Application no: **3/2019/0751**

Address: **Field off Lower Road Dutton PR3 2YL**

Proposal: **Erection of sheep shed with access tracks from existing vehicular accesses**

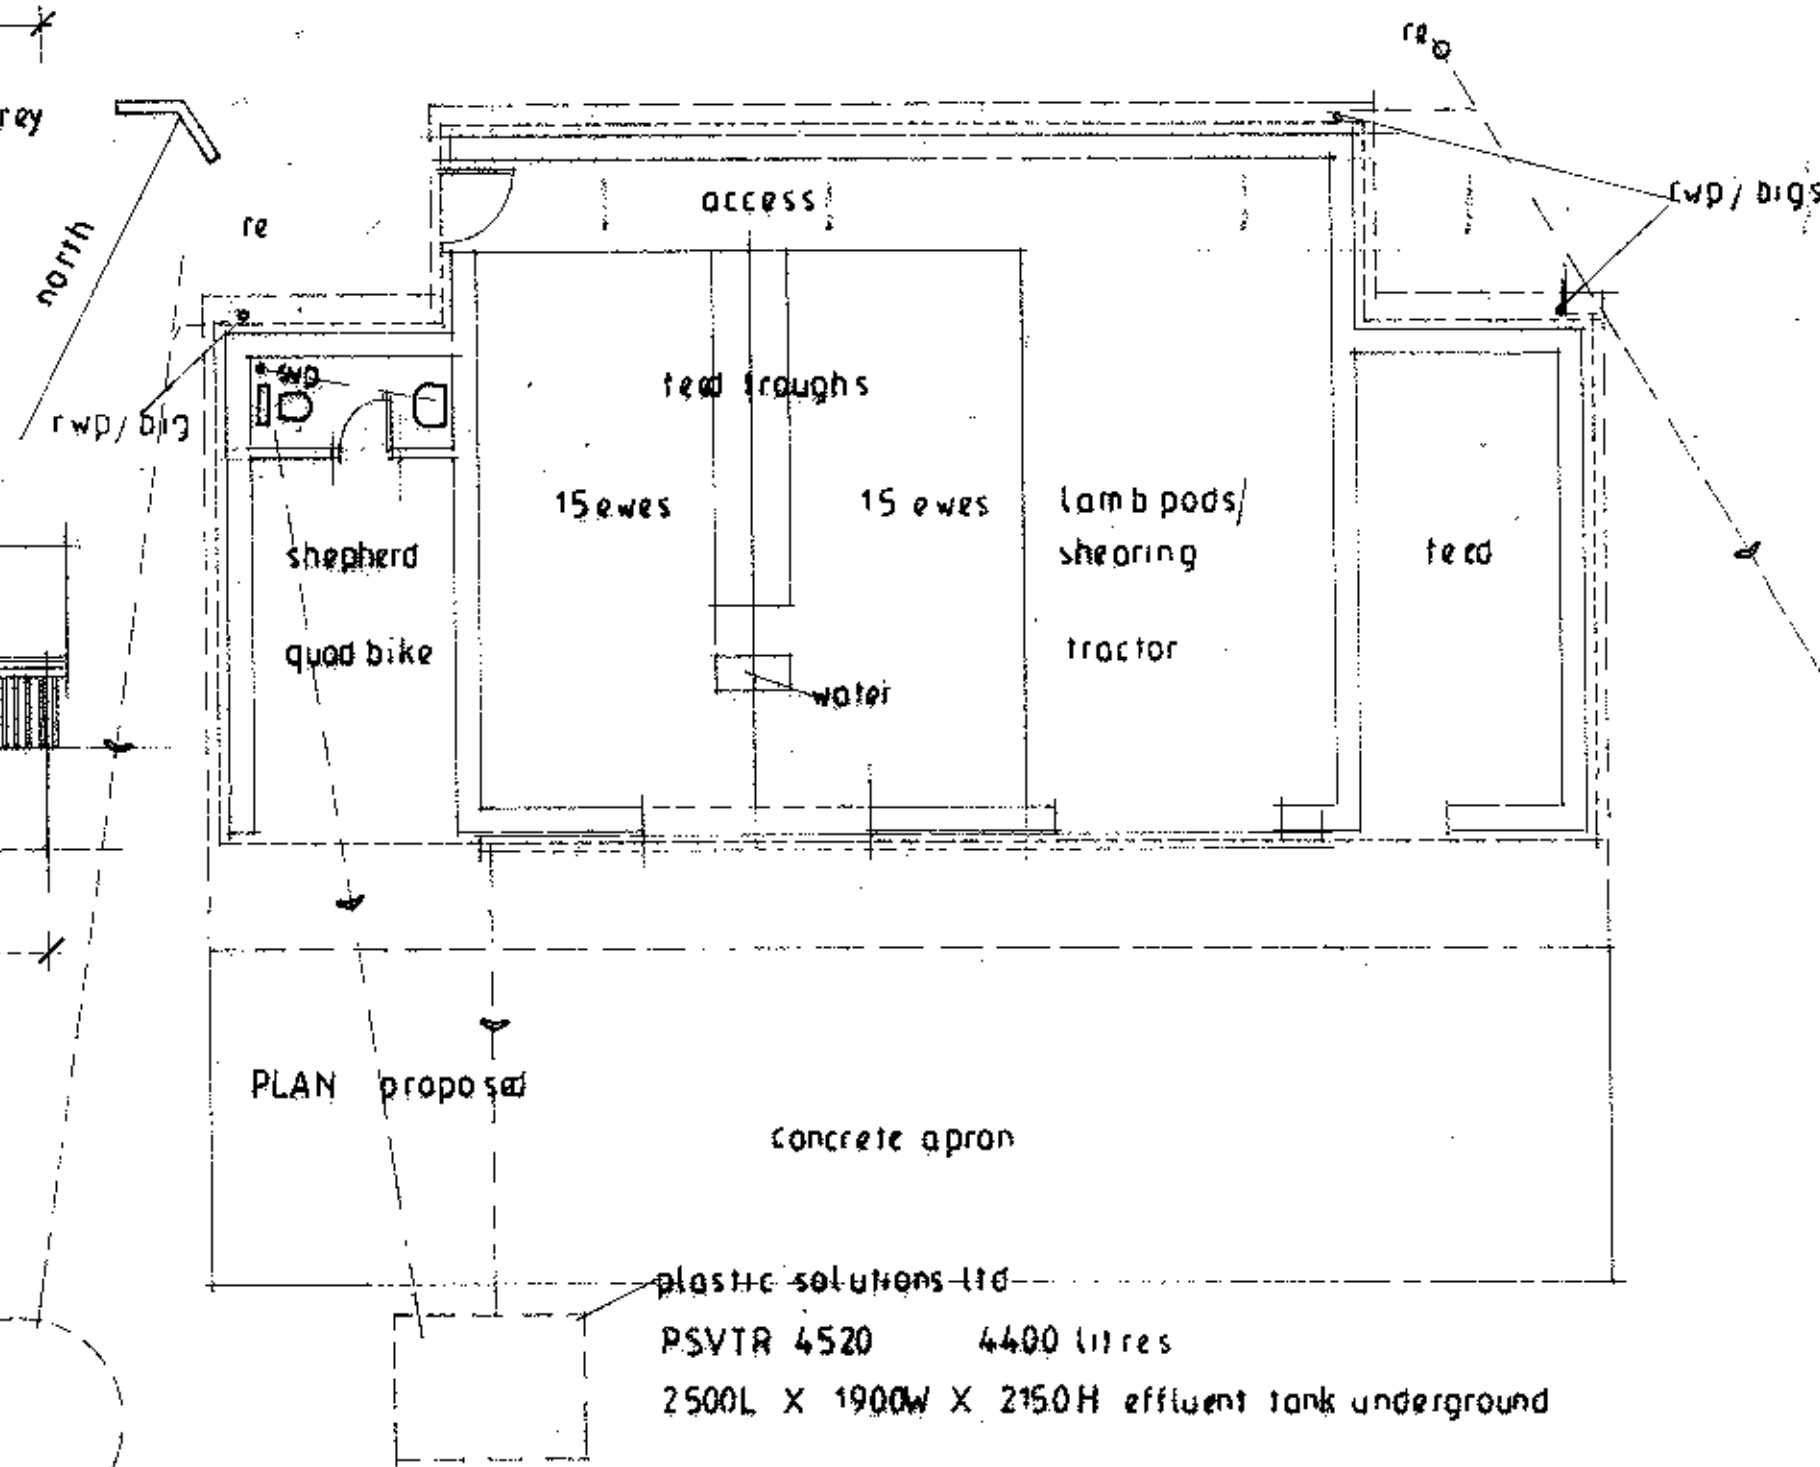
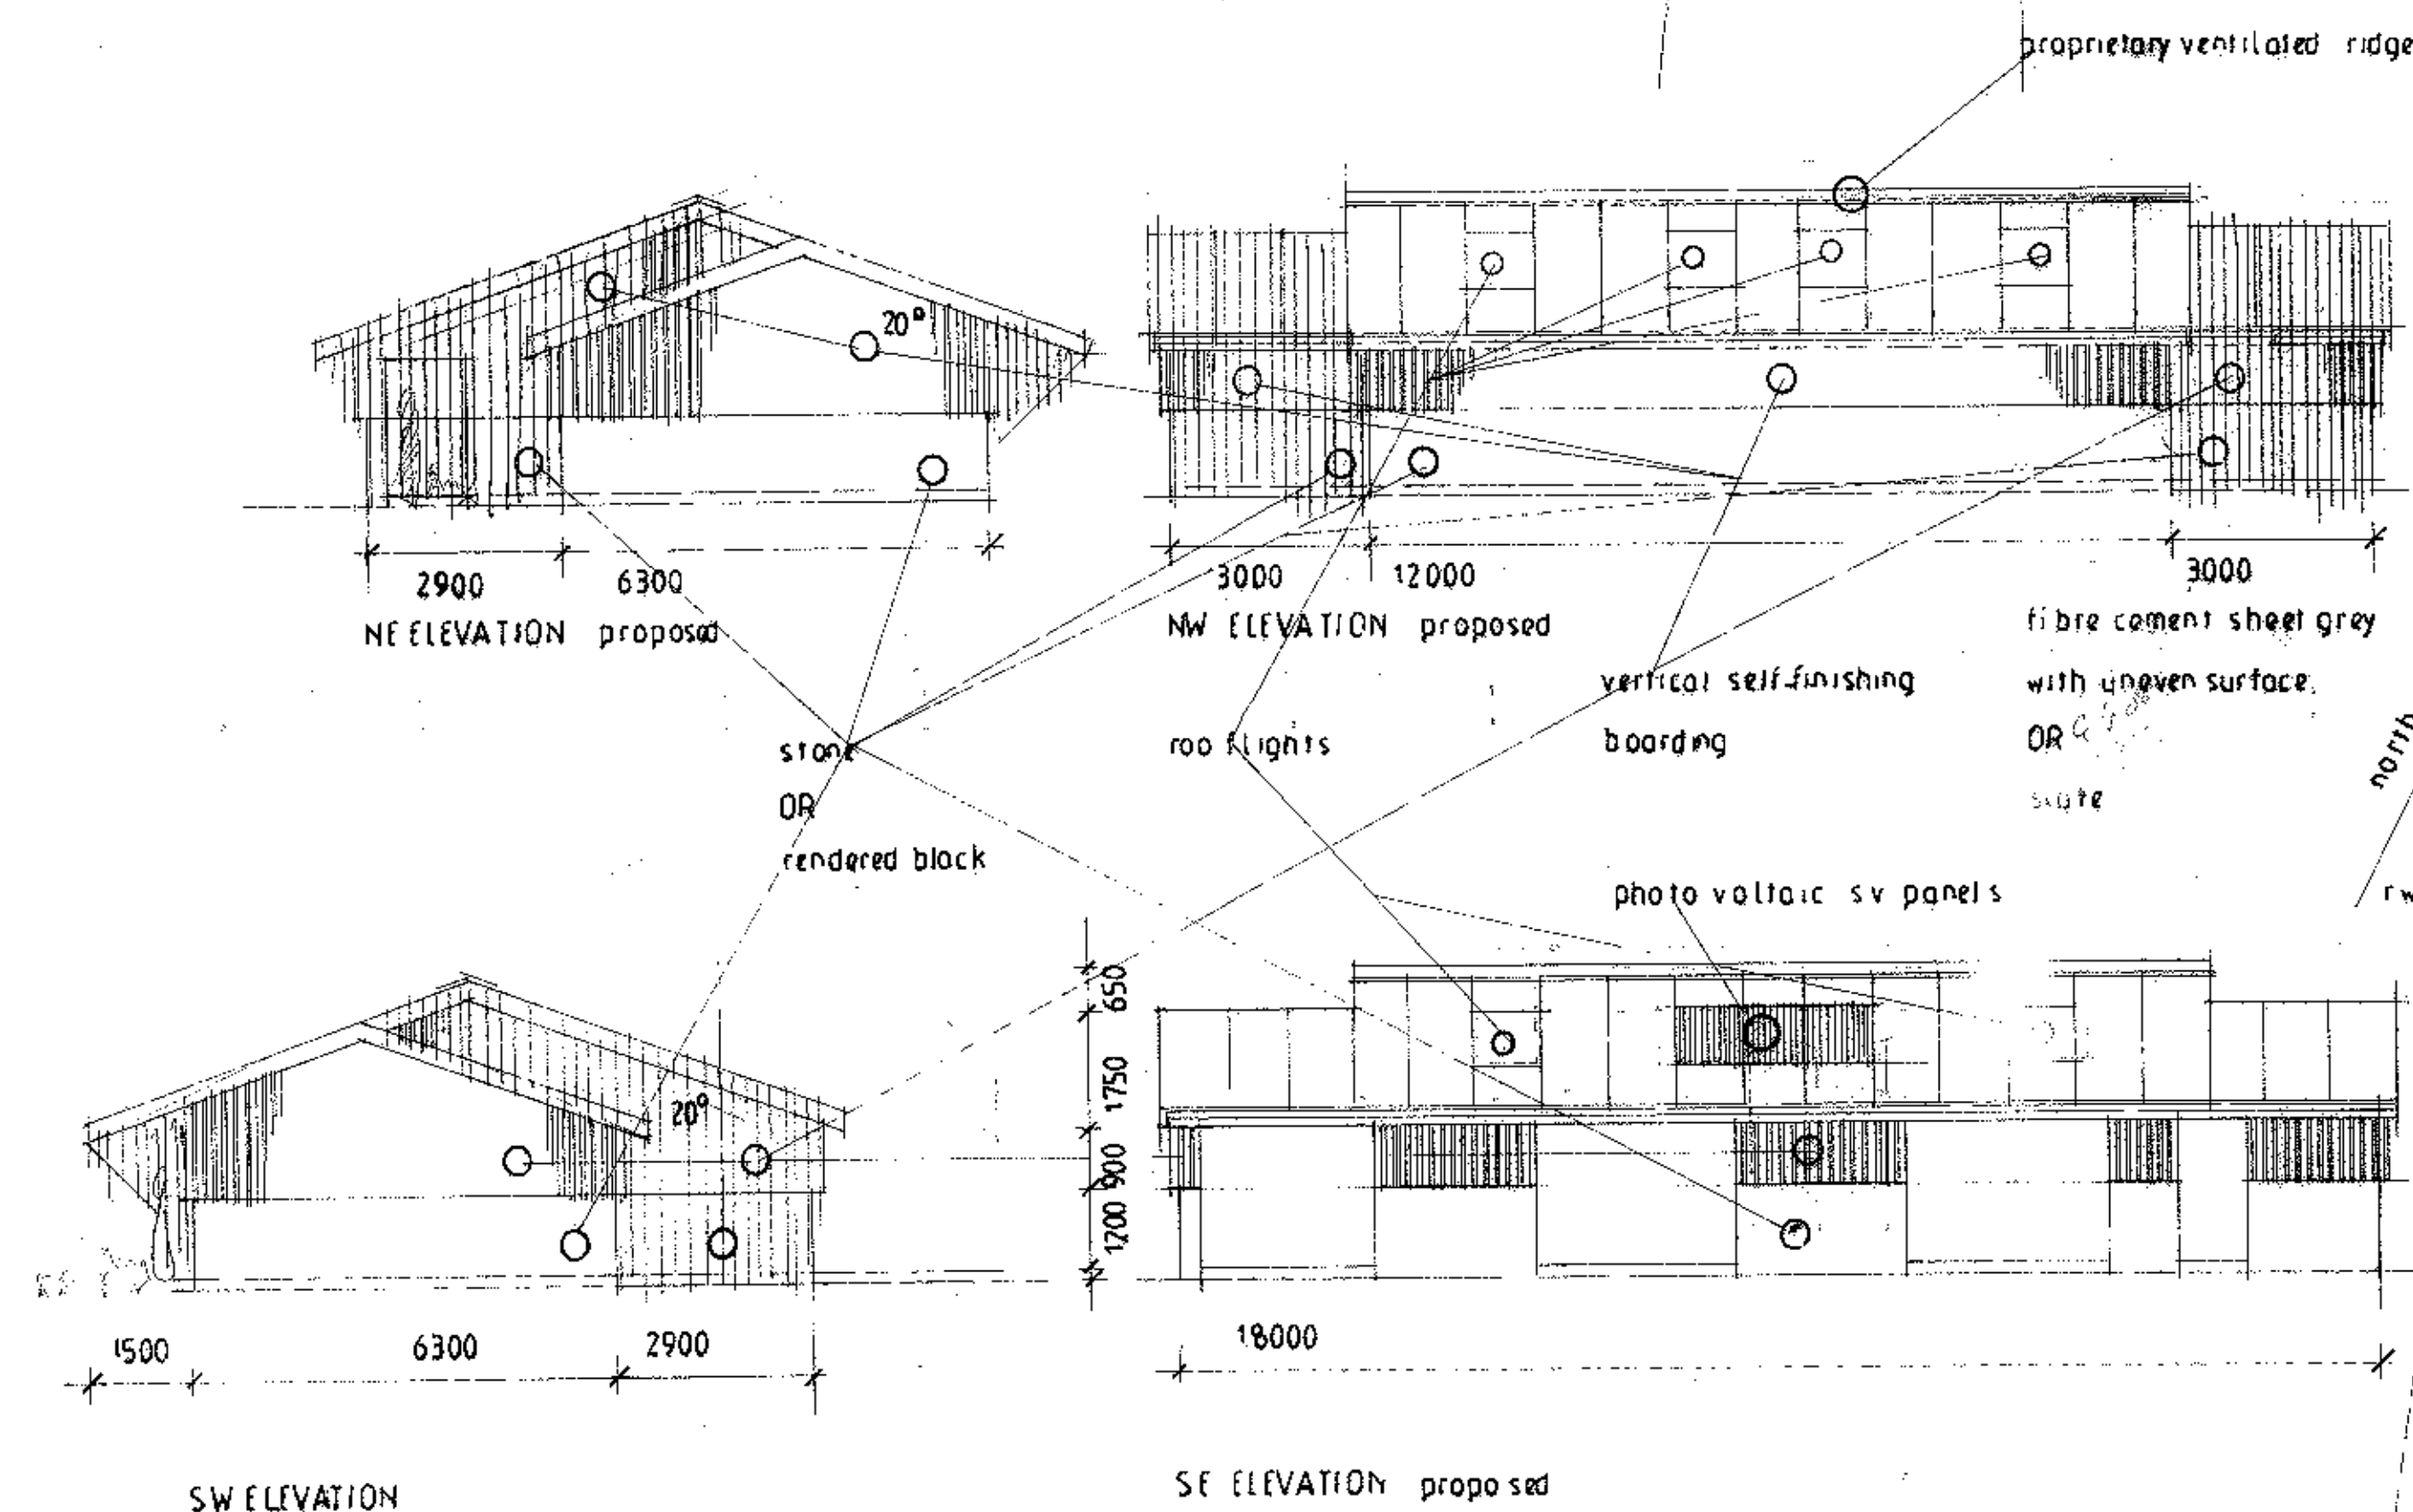
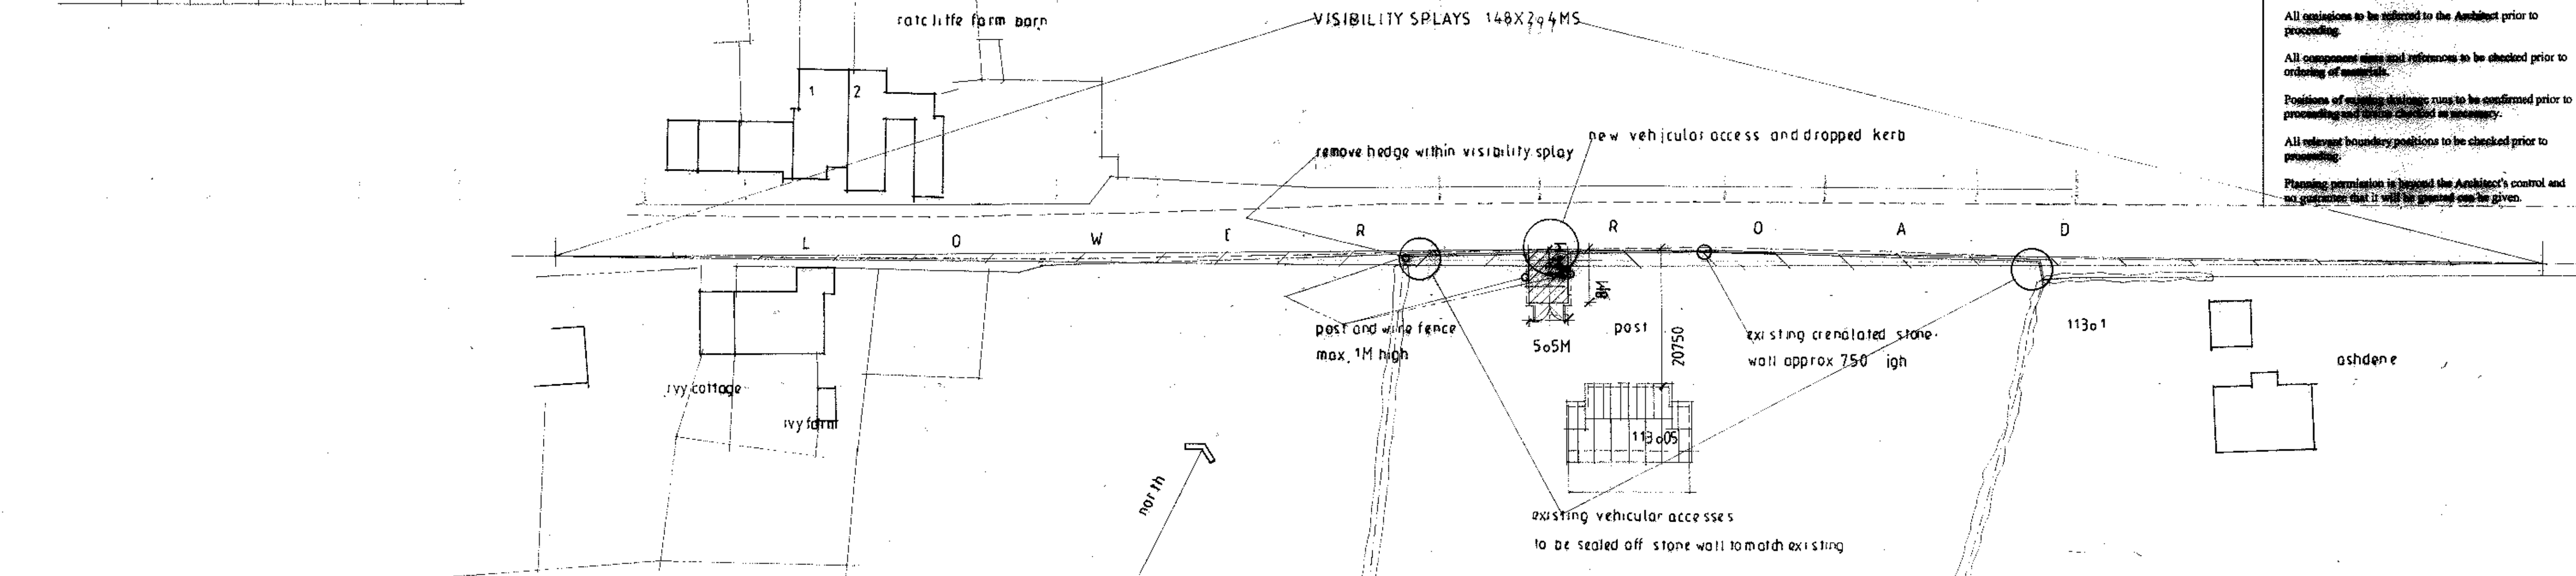
Access to the proposal is via Lower Road, a classified road namely B6243 which is also subject to the national speed limit. There are two existing gated access points which are to be stopped up as part of the proposal with a new opening being created within the boundary wall to serve a primary means of access to and from the application site.

The new access point is to be 5.5m wide and will also provide a gated access which is to be set back 8m from the rear of the adopted highway, the gates are also positioned to open into the field as opposed to outwards and in to the entrance. However, the first 5m of the access road will need to be bound with a permeable surface material to prevent any mud and debris being carried on to the classified adopted highway.

Visibility splays of 148m x 2.4m have been provided within the submitted plans and whilst Lower Road is subject to the national speed limit the proposed visibility splay would fall short of the expected sightline requirements for a road of the given speed limit. However, the proposed new access point is to be positioned in a more centralised location than that of the two existing access points and would therefore result in an improved access arrangement to the field and given the two access points are existing and there is no collision data reordered within proximity of the proposed access. Then the proposed Visibility splays of 148m x 2.4m would be considered sufficient for the proposal.

Post and wire fences are to be erected at either side of the proposed access, which are to be a maximum height of 1m and there is also a hedge which is to be removed at the most north-westerly point of the field to aid and increase highway visibility.

There is also a number of trees which are to be removed from within the boundary treatment of the field fronting Lower Road to again aid visibility and with all of the above in mind it would appear the applicant is doing as far as reasonably practicable to aid visibility at the application site, all of which is considered sufficient in support of the proposal.

1. Before the access is used for vehicular purposes, that part of the access extending from the highway boundary for a minimum distance of 5m into the site shall be appropriately paved in tarmacadam, concrete, block pavements, or other approved materials. **Reason:** To prevent loose surface material from being carried on to the public highway thus causing a potential source of danger to other road users.
2. Notwithstanding the provisions of the Town and Country Planning (General Permitted Development) Order 1995 there shall not at any time in connection

with the development hereby permitted be erected or planted or allowed to remain upon the land hereinafter defined any building, wall, fence, hedges, trees, shrubs or other devices over 1.05m above road level. **Reason:** To ensure adequate visibility at the street junction or site access.
